Planning Application Ref: **WA/50/20/RES**

Location: **Former Lanes End House, West Walberton Lane, Walberton, BN18 0QS**

Description of works: **Approval of reserved matters following outline consent WA/26/18/OUT for appearance, landscaping, layout & scale for the demolition of 1No. dwelling & the erection of 6 No. dwellings (resubmission following WA/7/19/RES).**

Mark Warwick
Tree Officer / Parks and Greenspace Team

PLOT 6
FLOOR PLANS AND
ELEVATIONS

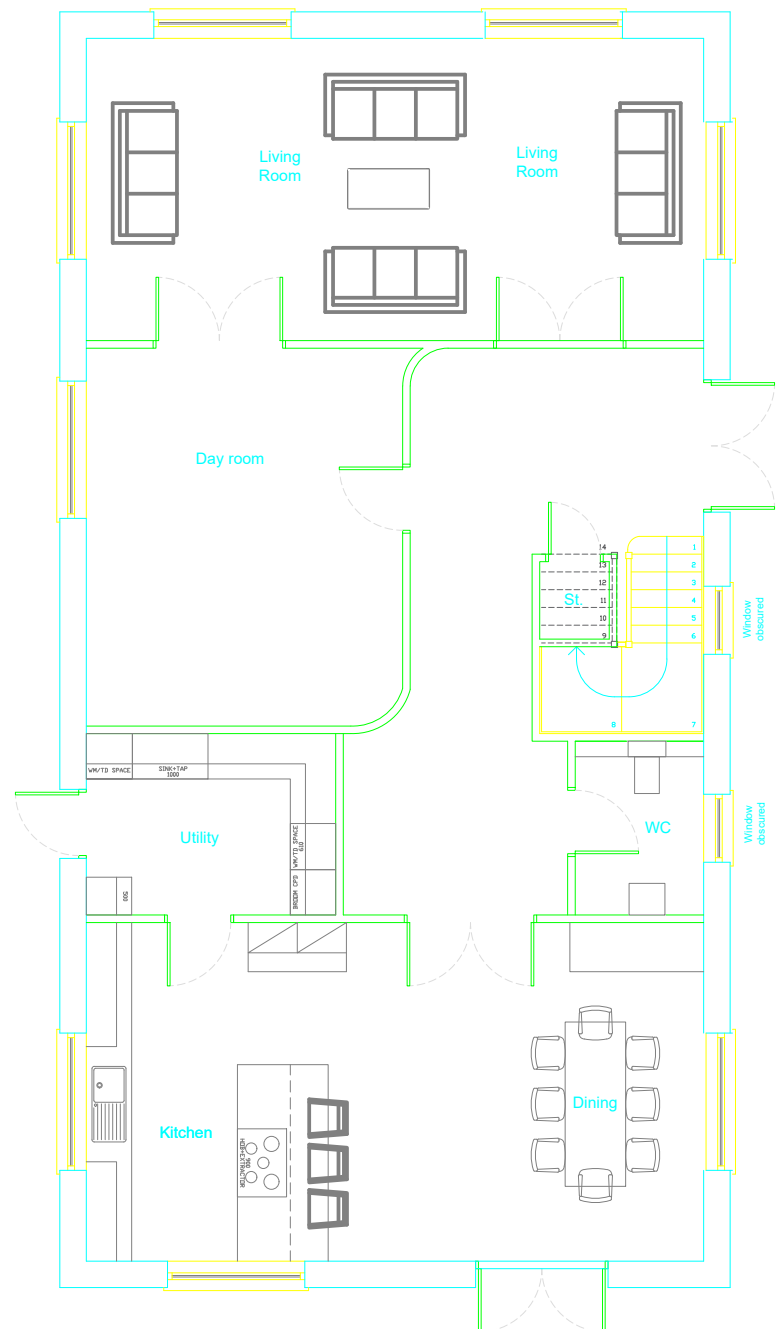
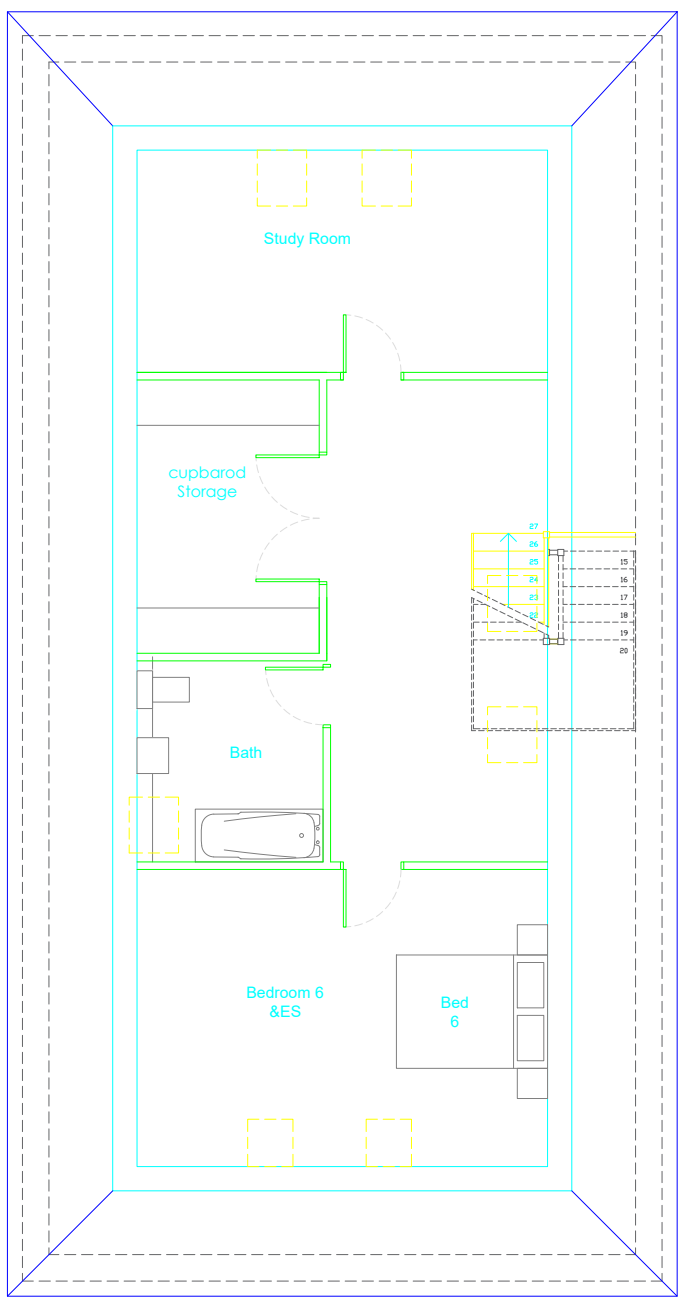
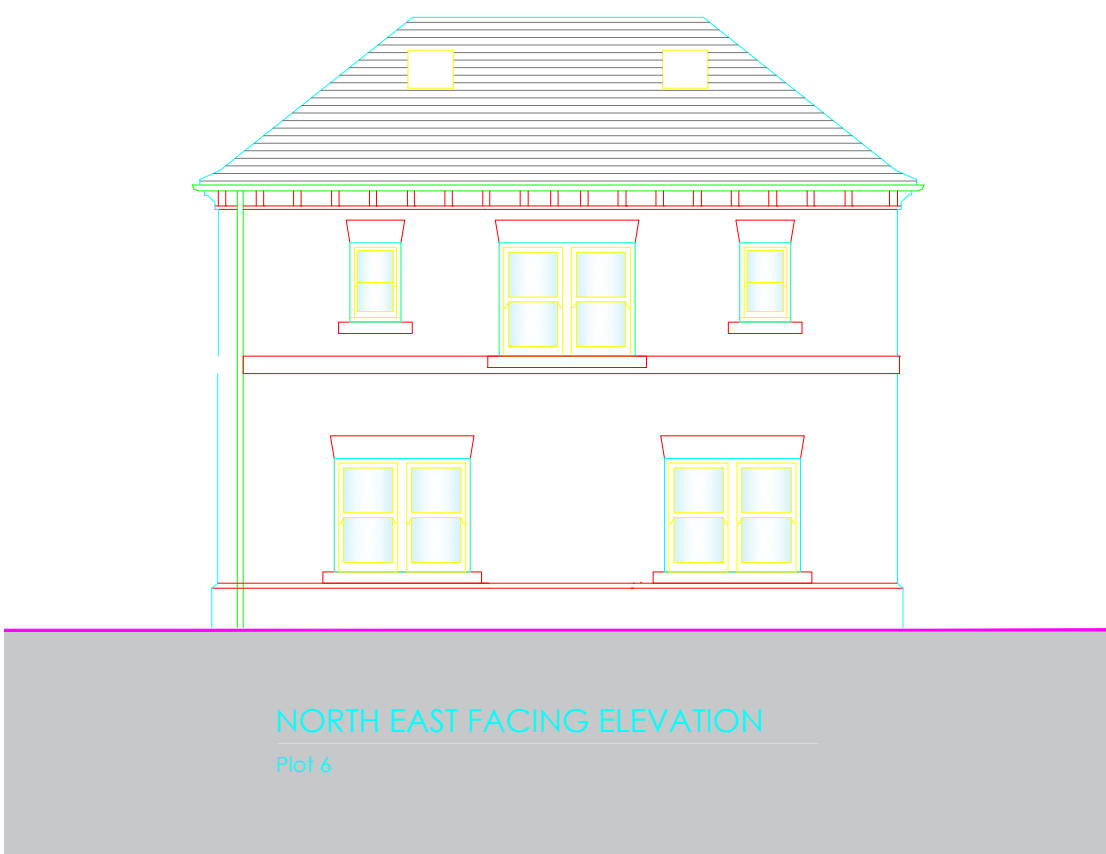
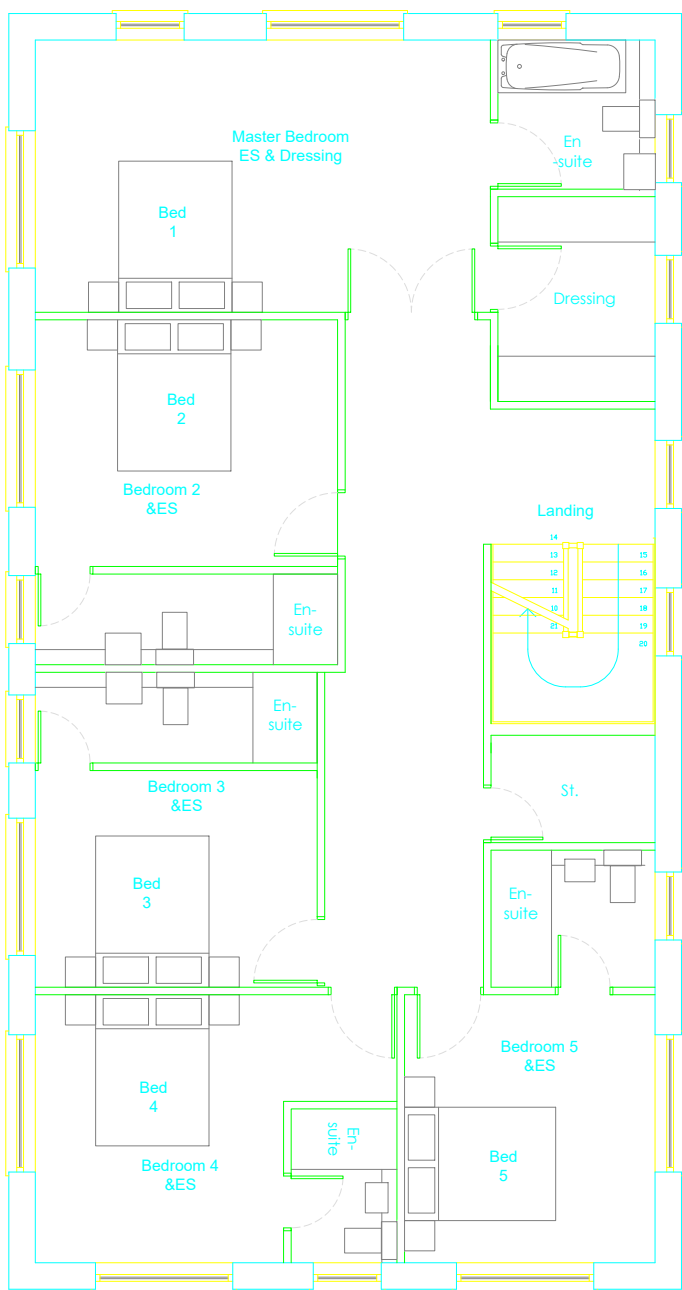
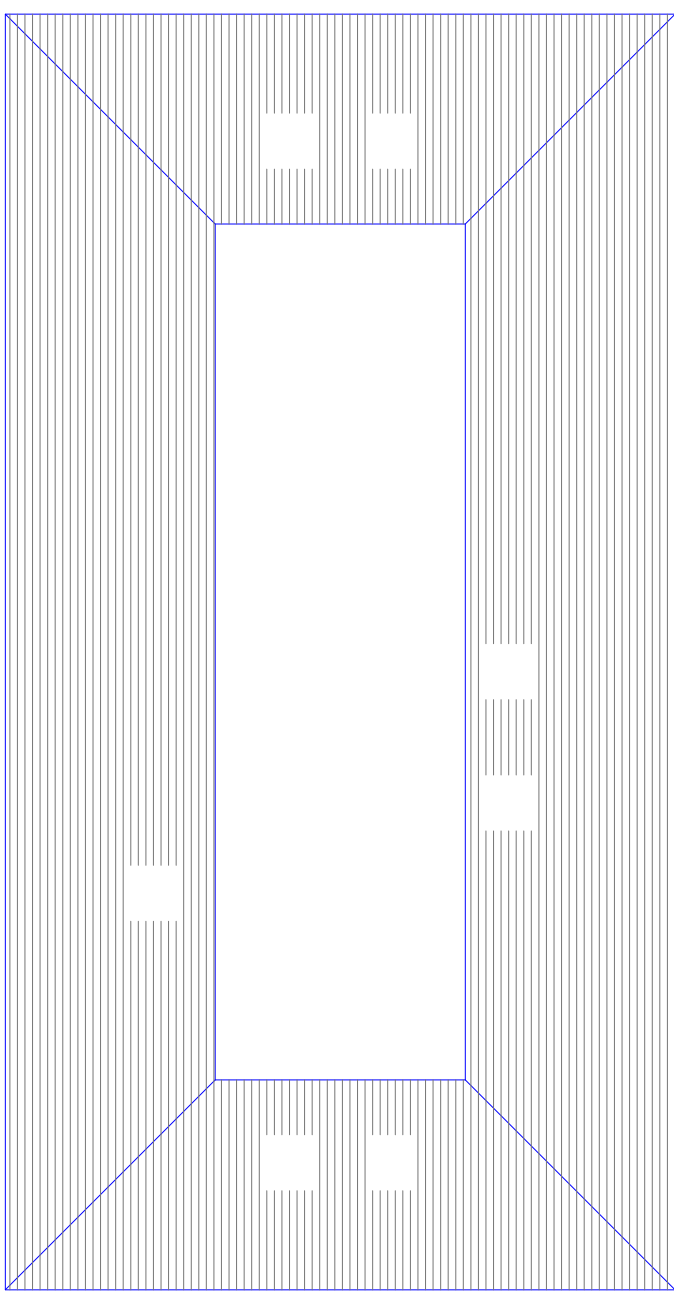
- This development does not seek to fully accommodate and benefit from the long-term presence of higher value trees. I recommend **removing plot 06** from the scheme to allow a **separation and movement north/re-orientation of plots 03 – 05 incl.** – so that all construction within Root Protection Areas (RPA) is avoided. Furthermore, that would reduce the effect of shading on dwellings from tree canopy (with subsequent residential pressure to prune) and ground compaction/introduction of garden installations over rooting zones.

TREE CONSTRAINTS PLAN

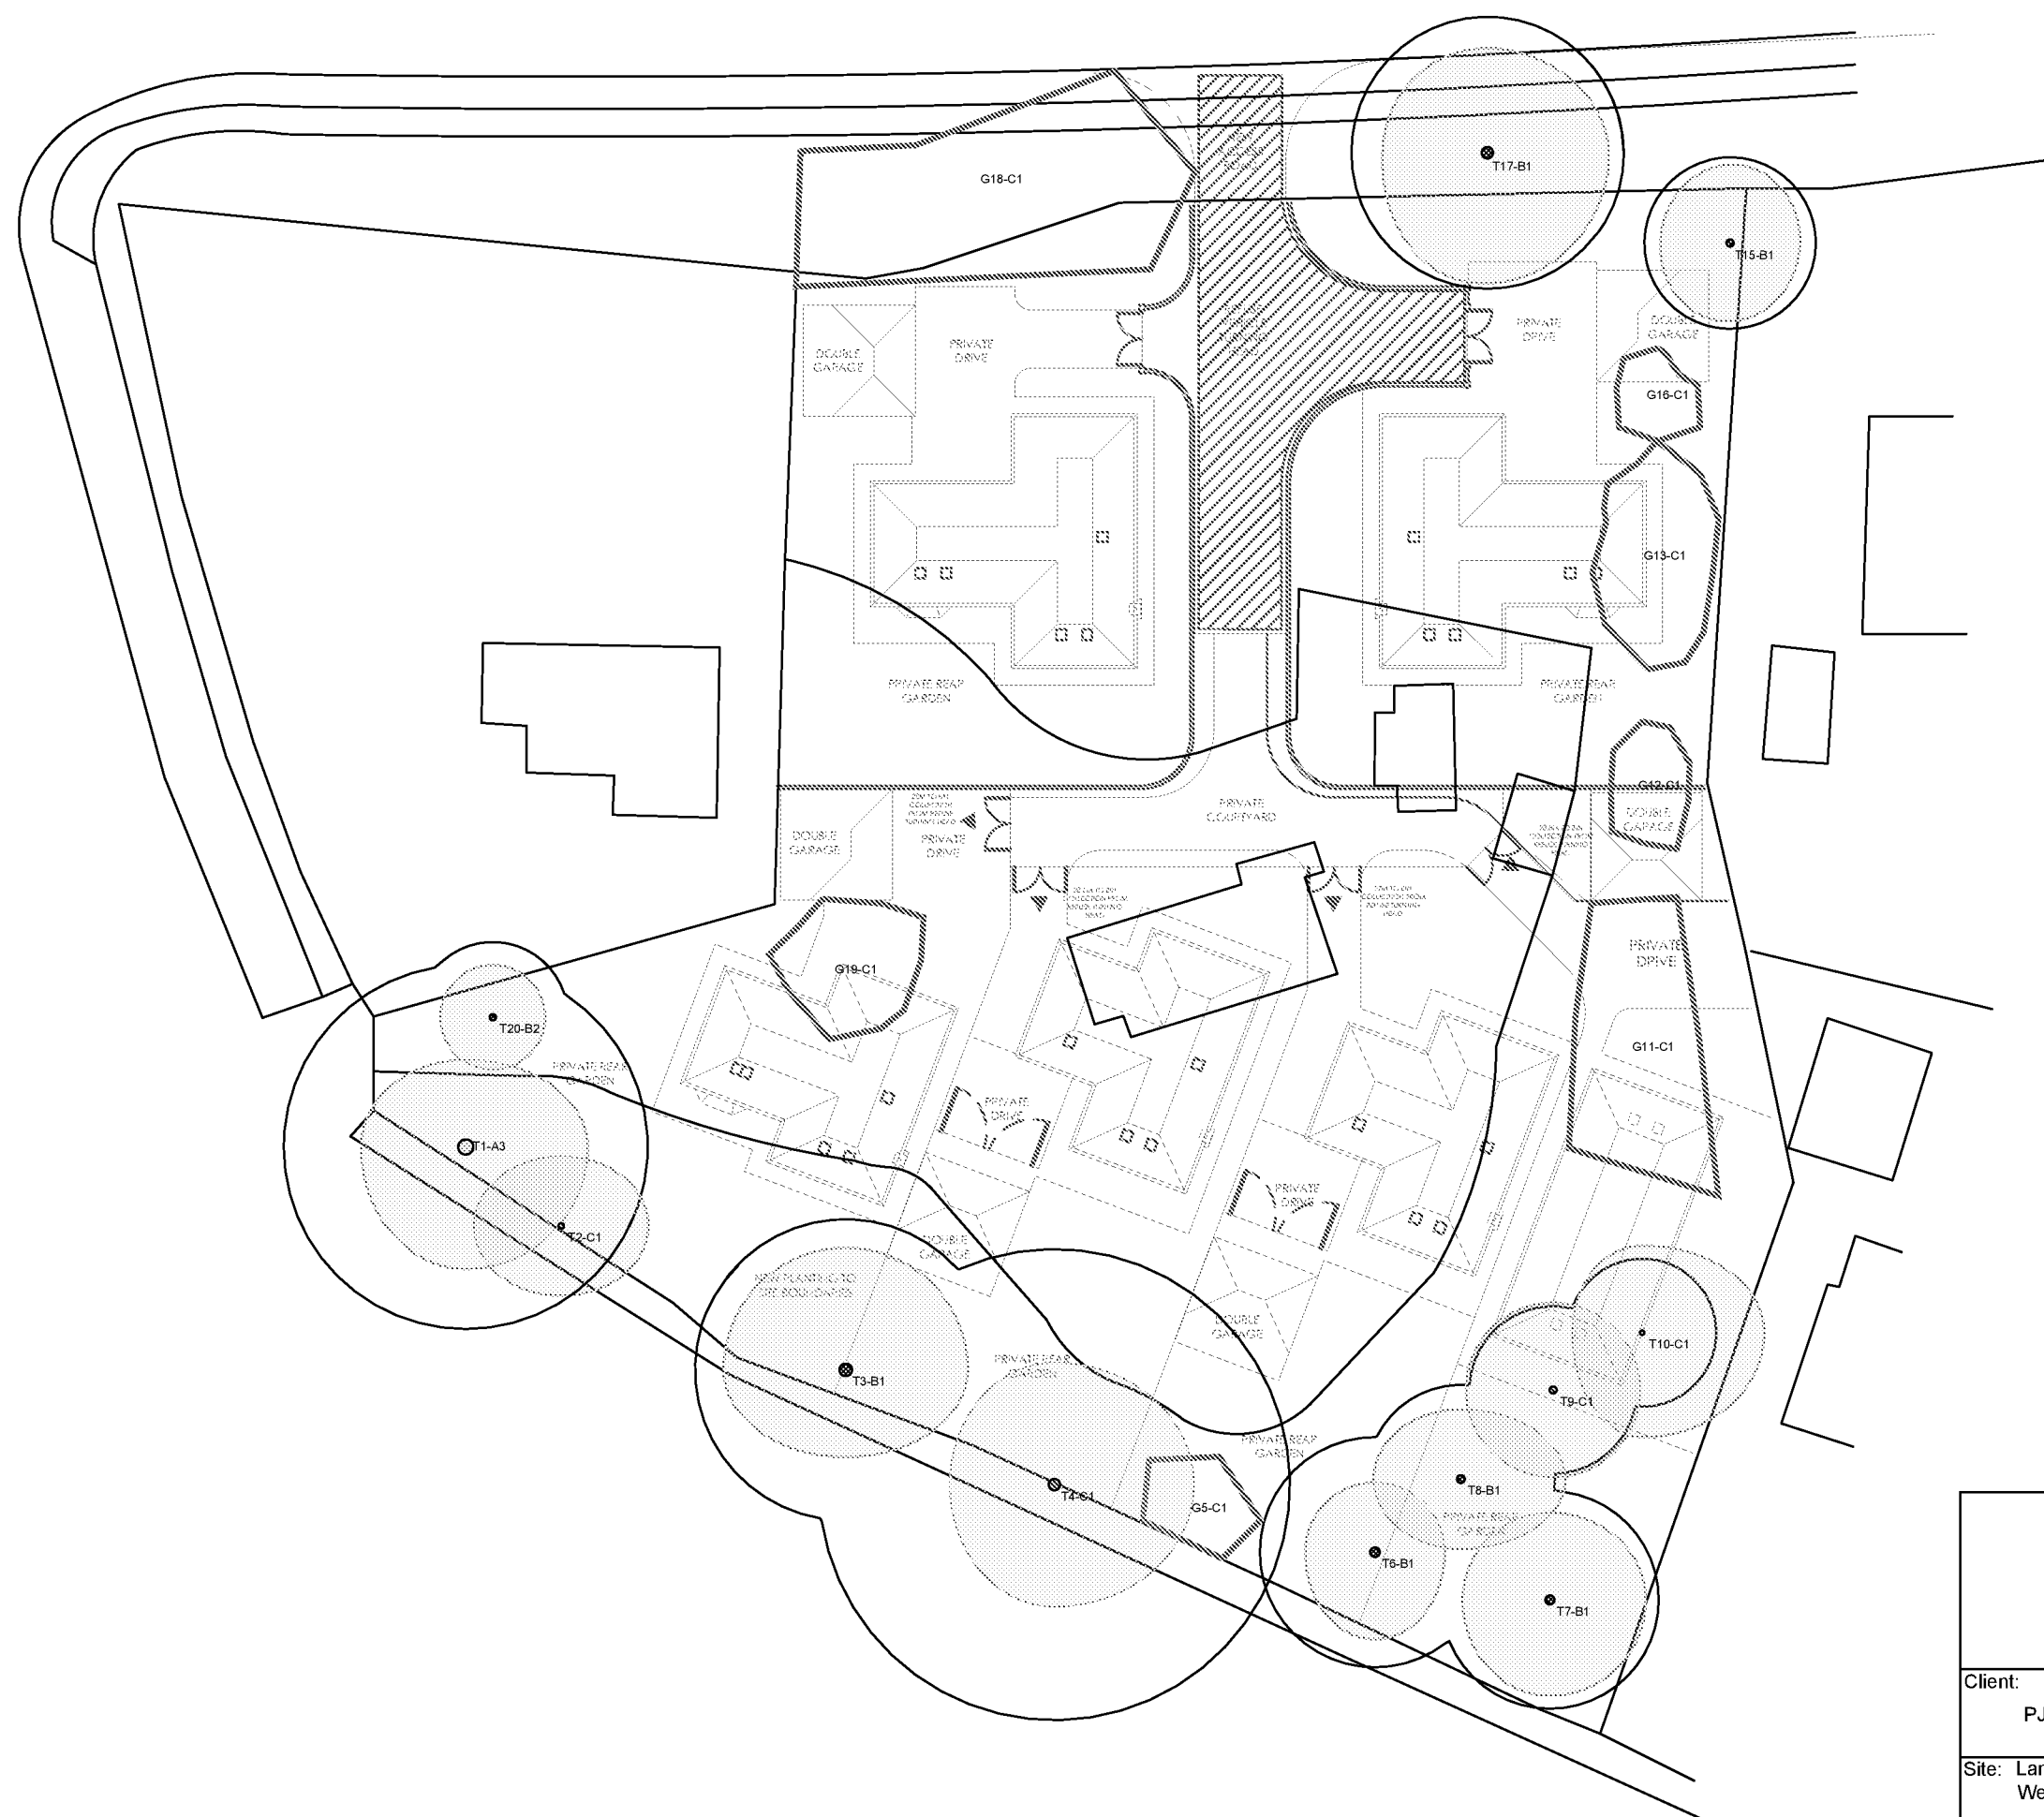
- The Tree Survey data is comprehensive and accords with the requirements of BS5837:2012. I am mostly in agreement with the retention category ratings applied, although take issue with T15 – yew, a TPO tree being assigned Category B.

- **The removal of T4** – established sycamore would seem to be **avoidable with a more sympathetic layout.** Established roadside trees of this size and form provide screening and contribute to the rural character of the lane.

- **T15 yew (TPO)** is young for its type and is in good condition with uniform crown. It should be a Category A tree and given ample room to flourish, not hemmed in by additional structures within its existing area of influence (crown/roots). Revise layout to fully respect **RPA plus minimum 2m buffer zone required.**

- **T17 oak (TPO).** Revise layout to fully respect **RPA plus minimum 2m buffer zone required.**
- There does not appear to be a surface water drainage (and foul water sewer) strategy for the site. This fundamental element of the design ought to be addressed to our satisfaction in association with layout proposals, so that we are not subsequently held hostage to essential measures which could then impact heavily on retained trees/landscape plans.
